From: Laura Gibbons
Sent: 14 September 2018 09:27
To: Planning.Responses
Subject: RE: Planning Consultation on: AL/79/18/PL

Engineers Comments Regarding Surface Water Drainage

APPLICATION NO: AL/79/18/PL

Description of Works: 1 No. bungalow with 3 bedrooms in the roof (replacing permitted application AL/79/17/CLE).

SITE PLAN

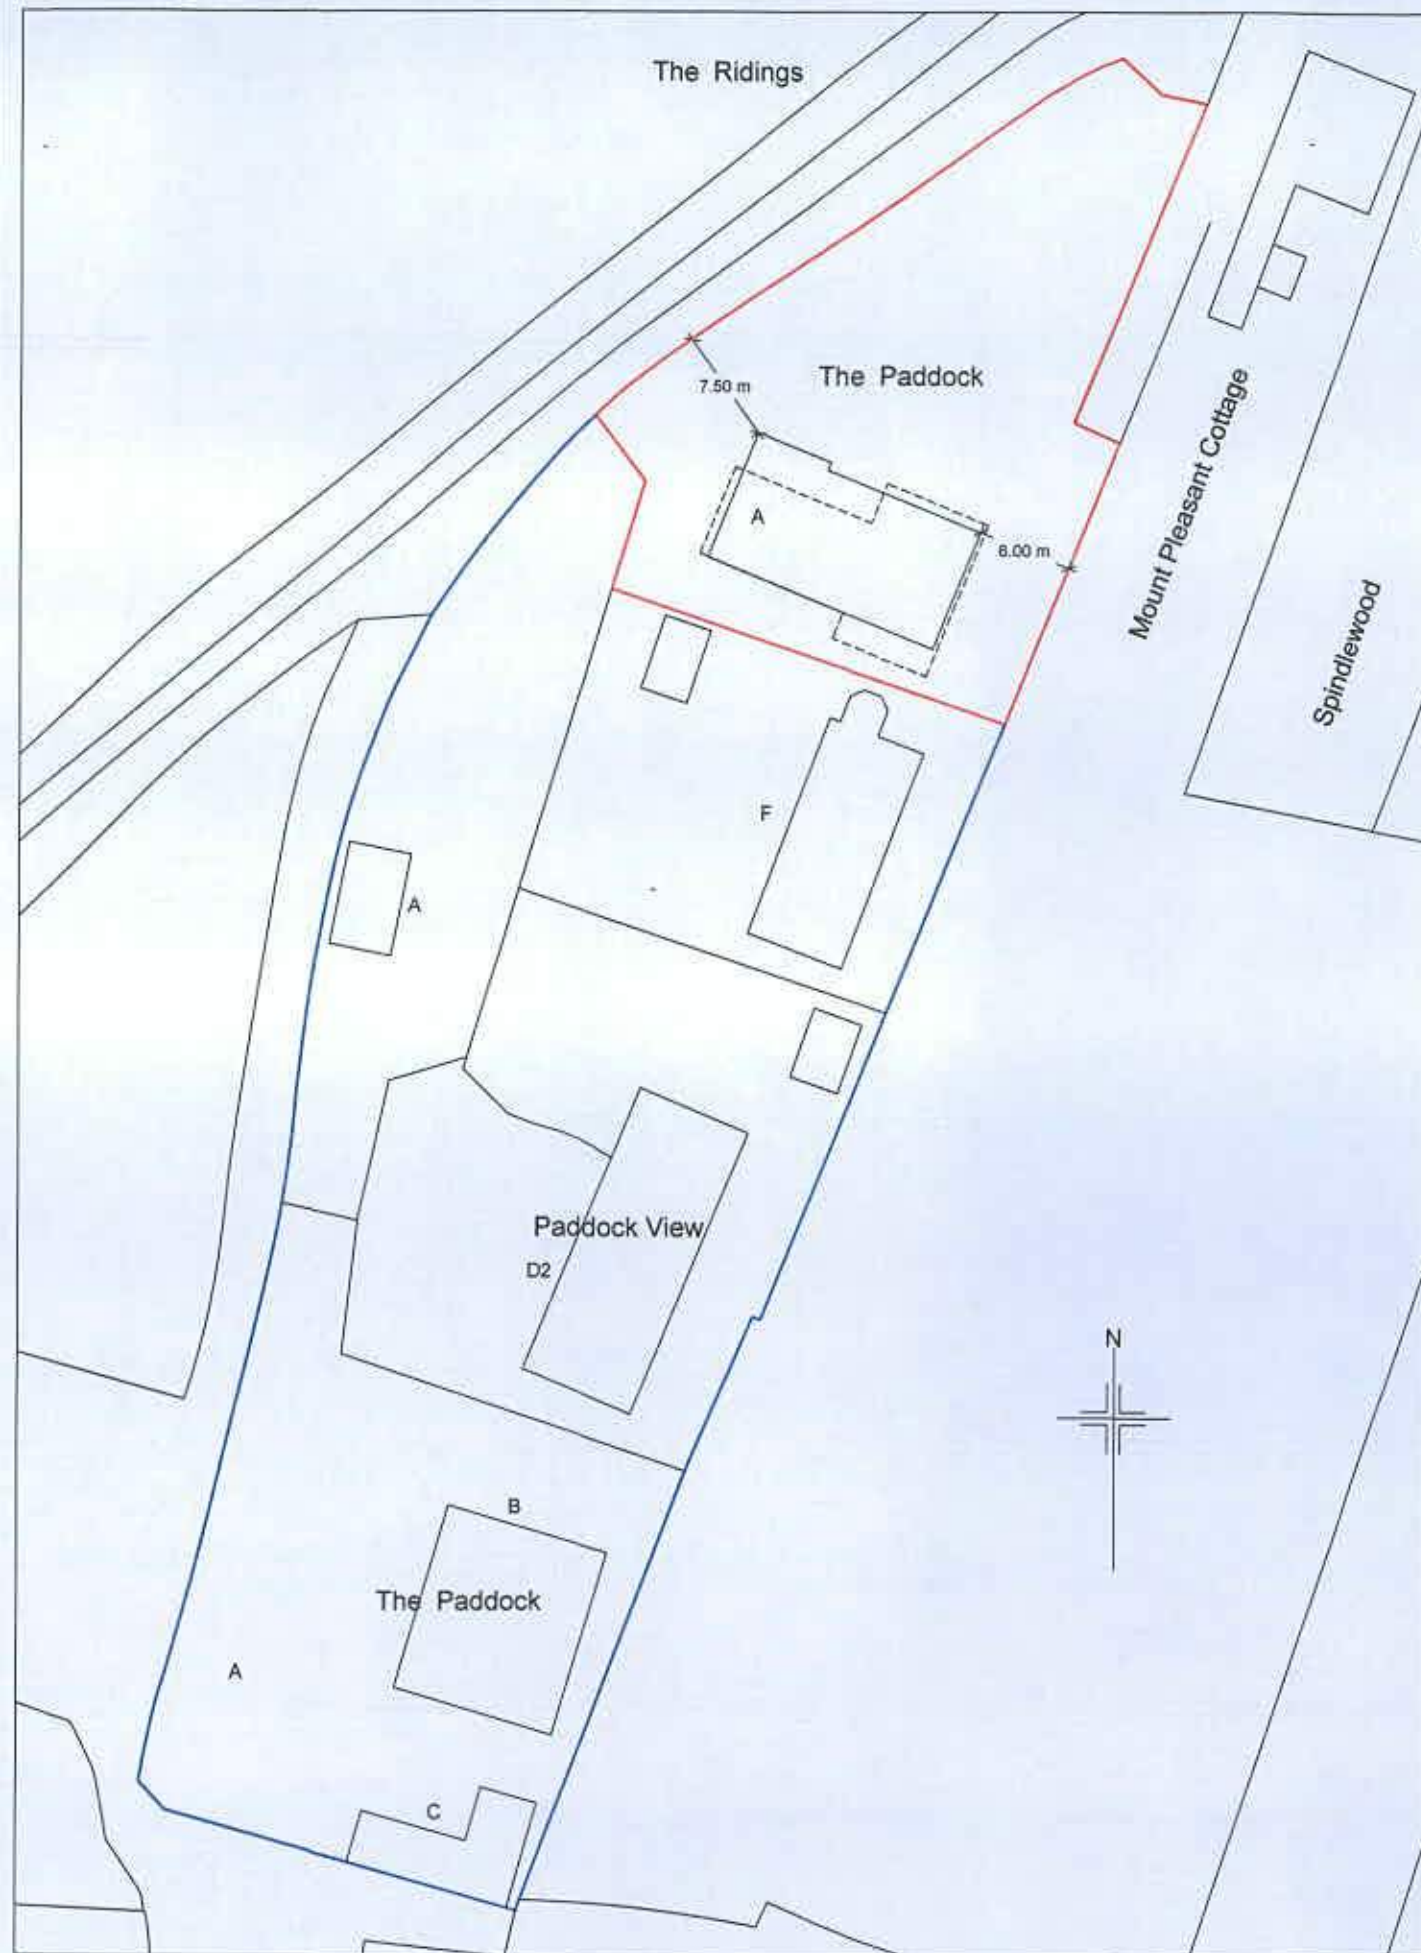
The site is within a surface water flood risk zone. Adequate measures should be provided to ensure that flood risk is not increased as a result of the development.

Soakaways must be investigated for surface water disposal.

Infiltration rates for soakage structures are to be based on percolation tests undertaken in the winter period and at the location and depth of the proposed structures. The percolation tests must be carried out in accordance with BRE 365, CIRIA R156 or a similar approved method and cater for the 1 in 10 year storm between the invert of the entry pipe to the soakaway, and the base of the structure. It must also have provision to ensure that there is capacity in the system to contain below ground level the 1 in 100 year event plus 40% on stored volumes, as an allowance for climate change. Adequate freeboard must be provided between the base of the soakaway structure and the highest recorded annual groundwater level identified in that location.

Any SuDS or soakaway design must include adequate groundwater monitoring data to determine the highest winter groundwater table in support of the design. The applicant is advised to discuss the extent of groundwater monitoring with the Council's Engineers. Supplementary guidance notes are also enclosed for information.
